Surface Water Drainage Comments;

F/26/17/DOC

1 - 4 Holm Oaks Land Adj to Northwood House Burndell Road
Ford

Application for approval of details reserved by condition
imposed under planning permission F/15/16/PL relating to
condition No. 3 (SuDs System and No. 4 (Landscaping
scheme)

**Surface Water
Drainage Layout**

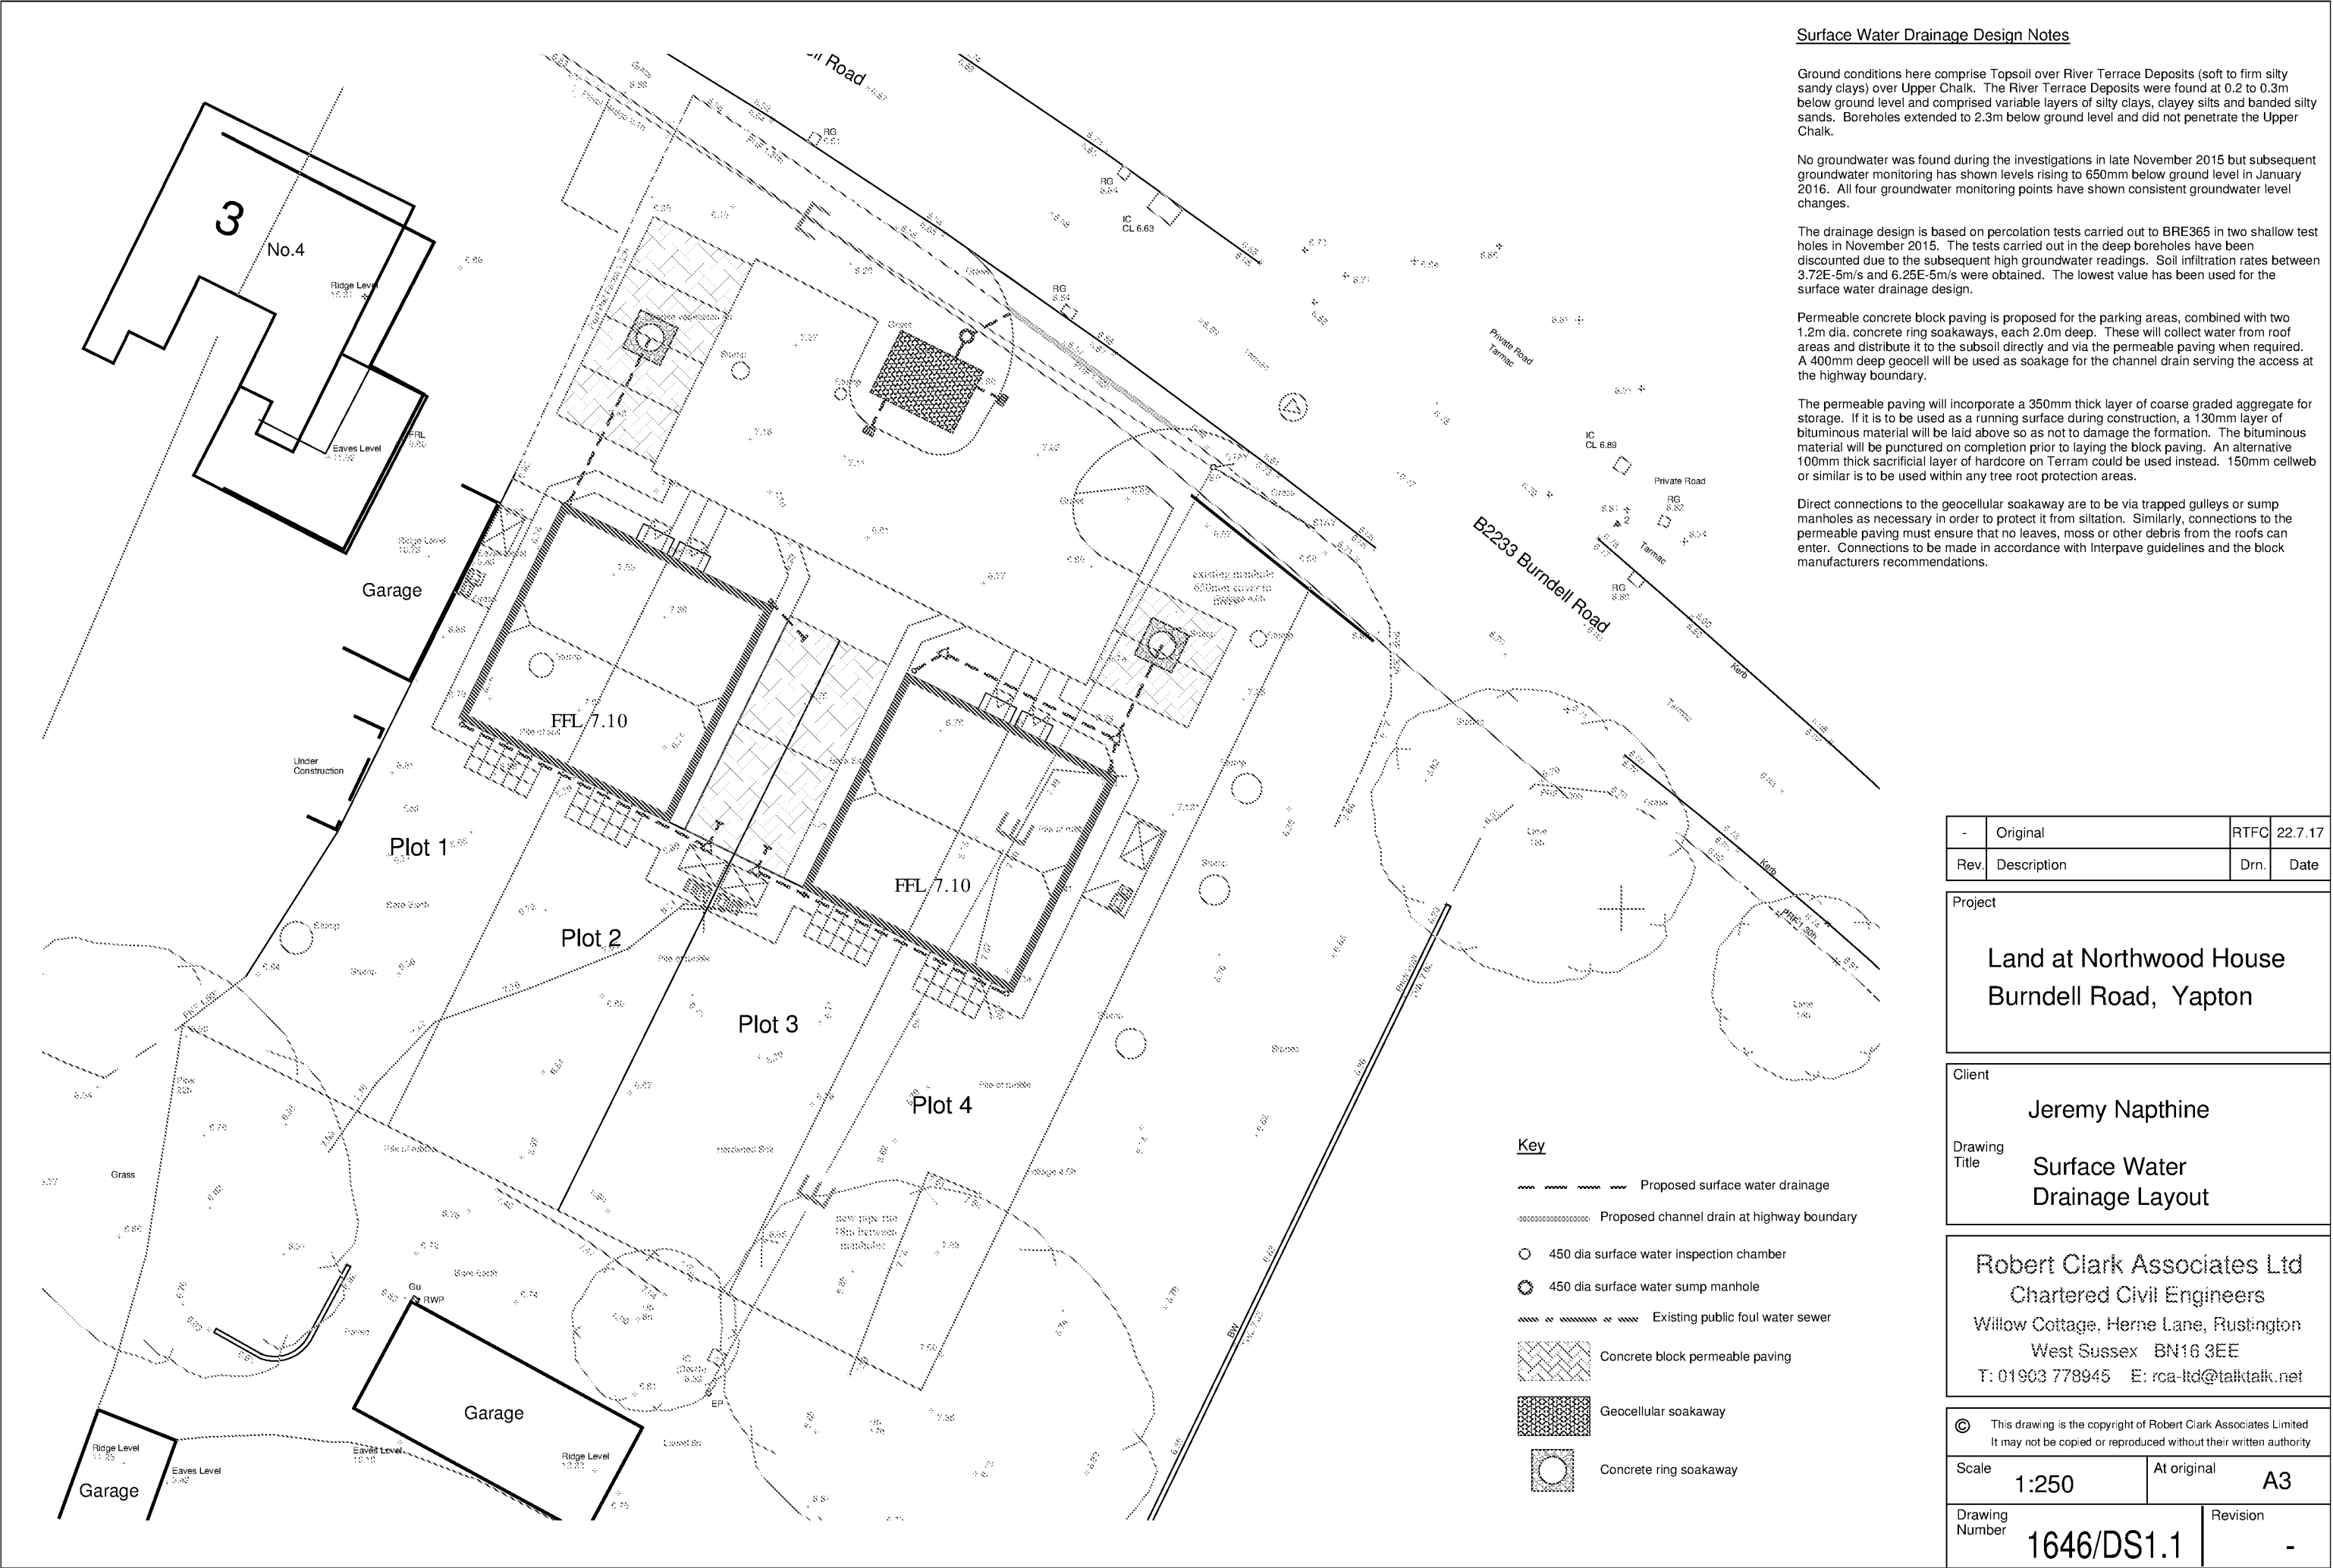
1. Full hydraulic calculations for the 1 in 100 year storm event + climate change allowance.
2. Full construction detail drawing of all drainage elements incl. permeable paving.
3. Specify pipe diameters and invert levels, etc.
